5816 Millais Hs. Ground Floor  
20 Apr 2021

Millbank Estate  
5816

Gunite  
United Living

EXISTING ELEVATION A (EAST)
Scale 1:100

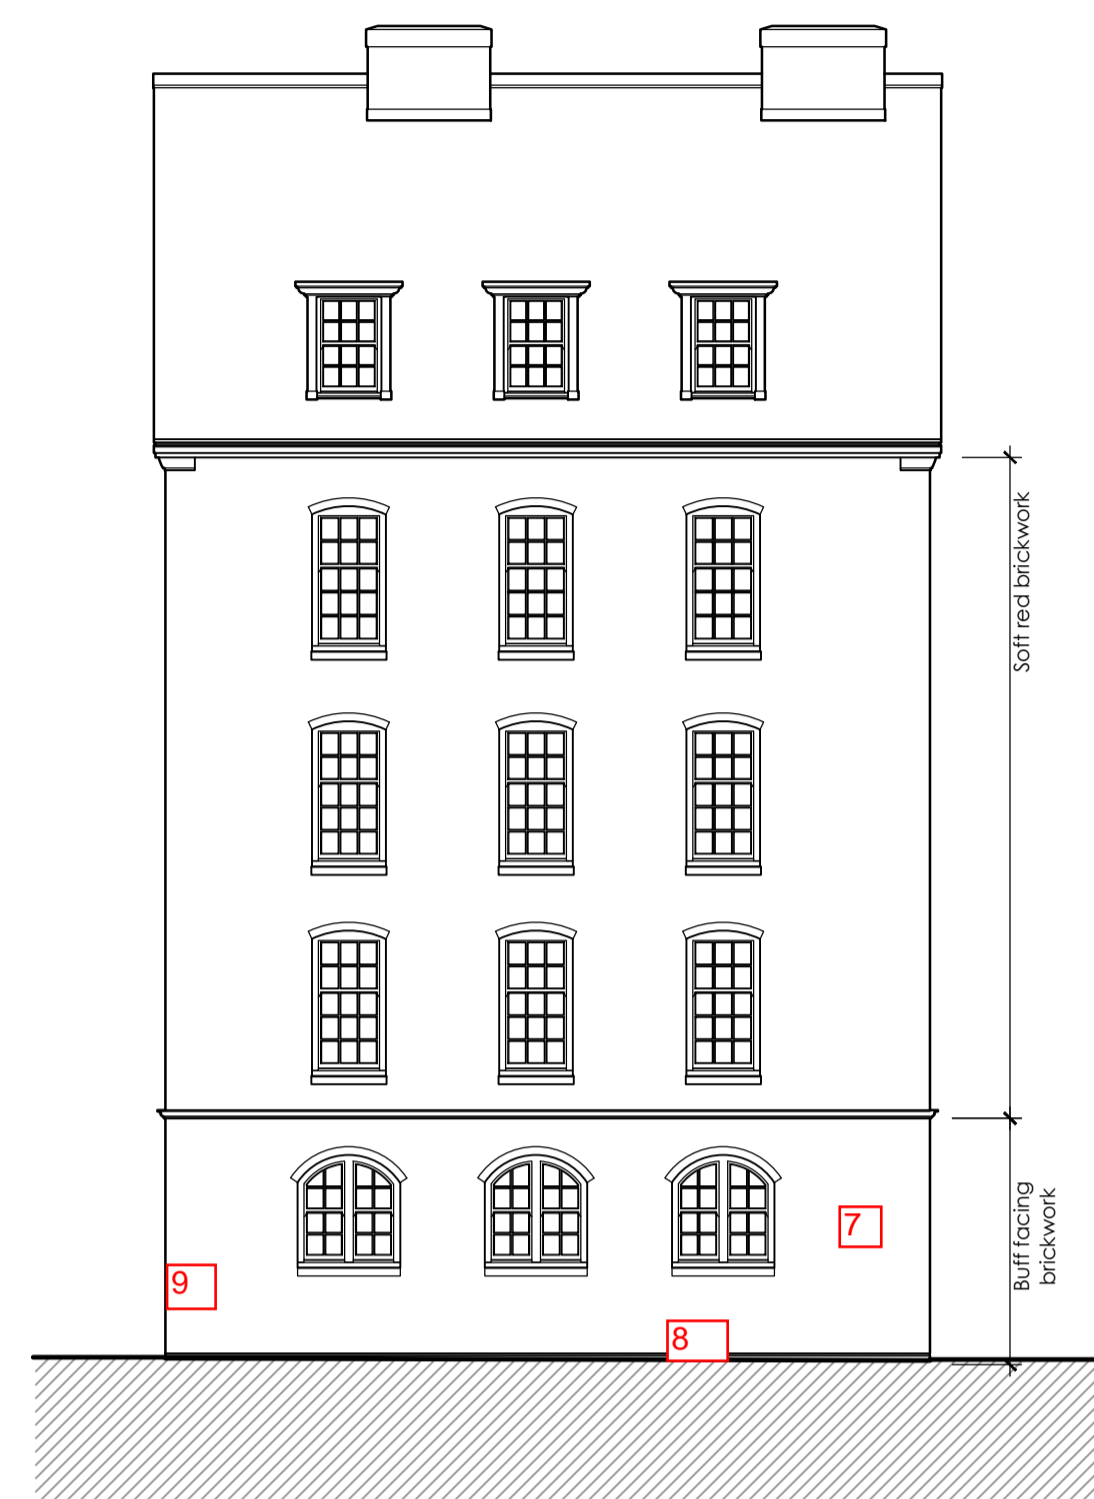
**ISSUE**  
Install cemties or helibeam as per structural engineer instruction

**COMMENTS**  
Structural engineer required

**ISSUE**  
As bove

**ISSUE**  
As above

**ISSUE**  
1 brick to replace

ISSUE  
2 bricks to replace

ISSUE  
2 helibars, 2 bricks to replace

**ISSUE**  
6 bricks

**COMMENTS**  
Existing brick repairs

**ISSUE**  
10 bricks

**COMMENTS**  
Existing brick repairs

EXISTING ELEVATION C (EAST)
Scale 1:100

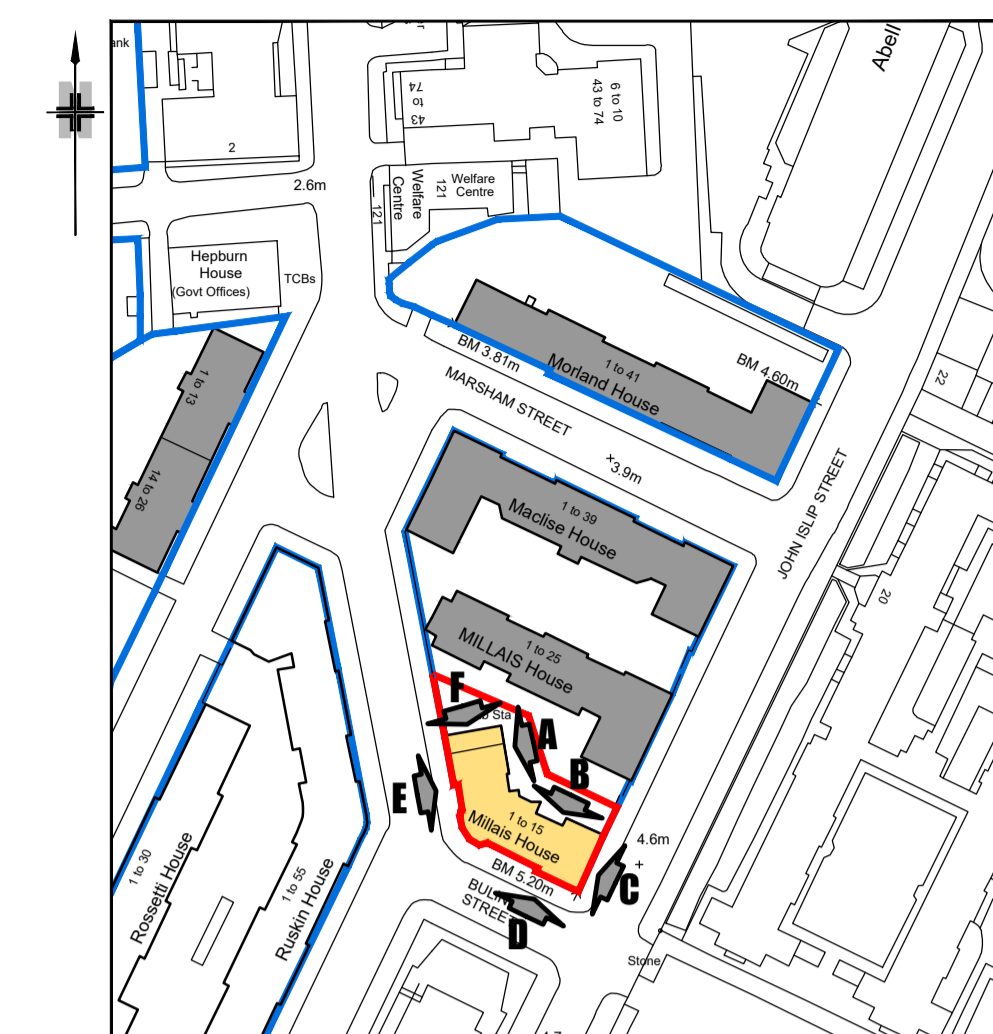
ISSUE  
1 brick to replace

ISSUE  
0.25 sqm pointing

ISSUE  
1 brick to replace

EXISTING ELEVATION D (SOUTH WEST)
Scale 1:100

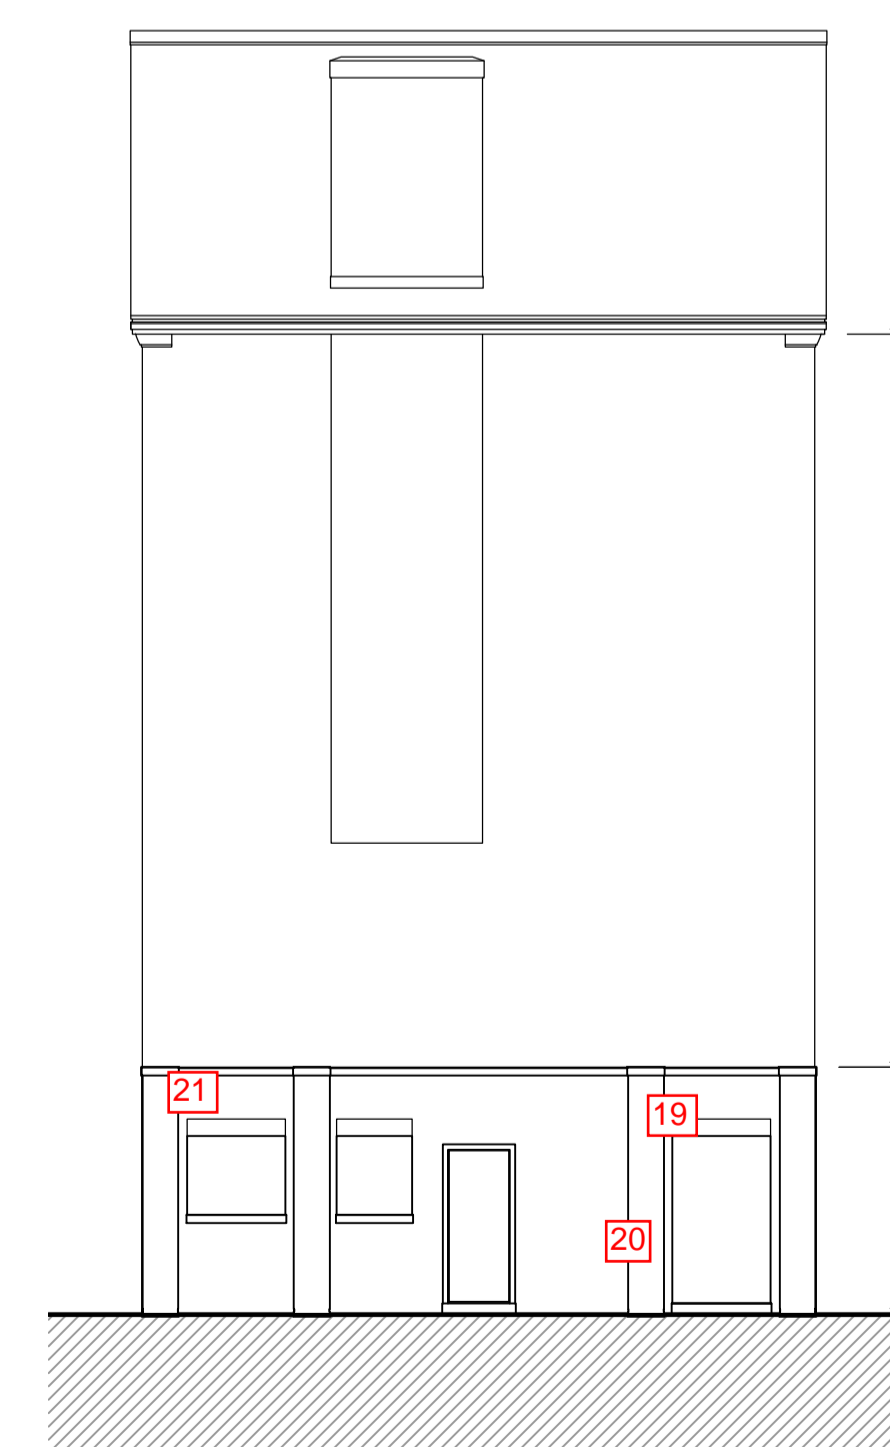
ISSUE  
1 brick to replace

ISSUE  
1 brick to replace

ISSUE  
1 brick to replace

ISSUE  
4 helibars, 5 bricks to replace

ISSUE  
1 brick to replace

ISSUE  
Install cementies or helibeam as per structural engineer instruction

COMMENTS  
Structural engineer required

ISSUE  
Install cementies or helibeam as per structural engineer instruction

COMMENTS  
Structural engineer required

**ISSUE**  
Install cemties or helibeam as per structural engineer instruction

**COMMENTS**  
Structural engineer required

**ISSUE**  
Install cemties or helibeam as per structural engineer instruction

**COMMENTS**  
Structural engineer required

**ISSUE**  
Install cemties or helibeam as per structural engineer instruction

**COMMENTS**  
Structural engineer required

**ISSUE**  
2 bricks to replace

**ISSUE**  
Install cement ties or helibeam as per structural engineer instruction

**COMMENTS**  
Structural engineer required
